**F/15/24/RES**

*Land at Ford Airfield Ford*

*Approval of reserved matters (layout, scale, appearance and landscaping) following outline permission F/4/20/OUT for phase reserved matters 1 (North), for the erection of 340 No. residential dwellings plus associated roads, infrastructure, parking, landscaping, open space & play areas and associated works.*

**Recommendation: Further information required**

Figure 6.1. RM1 - proposed St Mary's Meadow western edge landscape buffer

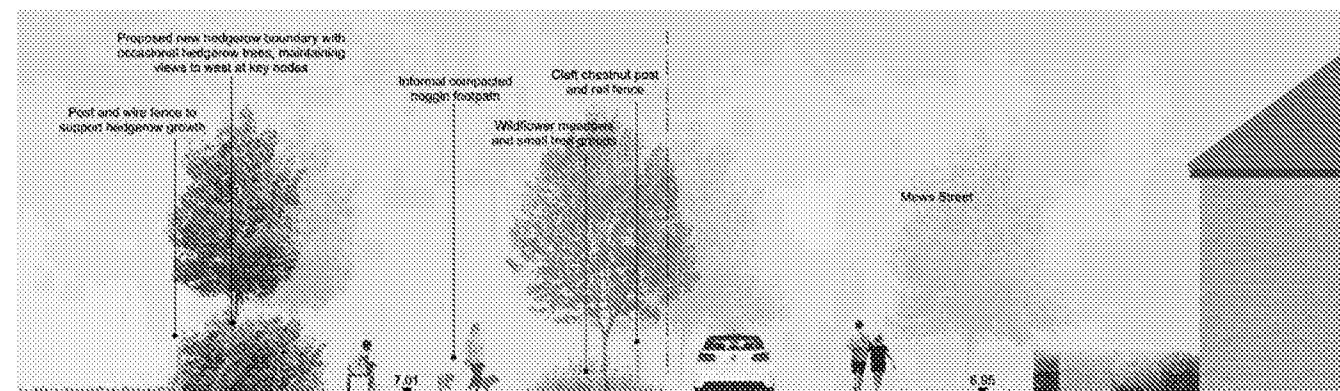
The north-western portion of the site will consist of a large area of housing identified as the St Marys Meadow character area. This part of the site is close to the Yapton Church Lane Conservation Area, which is characterised by the church and its churchyard, Church Farmhouse, and three substantial houses. The conservation area is described as a loose grouping of buildings with high substantial flint boundary walls, mature landscaping including many substantial trees that enhance the rural character of the area, which forms its setting. Whilst the church is largely screened from the wider countryside to the east (i.e. the direction of the application site), the countryside forms the agricultural context of both the church and the Conservation Area. As such, the fields form part of their wider setting.

This area of housing will be located to the west of a thick line of tall trees and will be created thorough the division of an existing field into two. The area of farmland closest to the conservation area/listed buildings will create a buffer type space between the heritage assets and the development. The division of the site will result in the creation of a new boundary line, which will need to be carefully considered as part of the landscaping.

Whilst the housing in the character areas attempts to meet the requirements of the design code, it is important that the landscaping for the western boundary is appropriate.

As with other areas of the site, I would be looking for the boundary to consist of native species which are typical of the rural character of the locality. I also believe that the trees should also be more mature on planting for a more instant impact, which will help to ensure that the remaining setting of the listed building is not impacted. The planting schedule will need to be prepared in agreement with our Parks and Landscape Office who has the technical knowledge on this detailed issue.
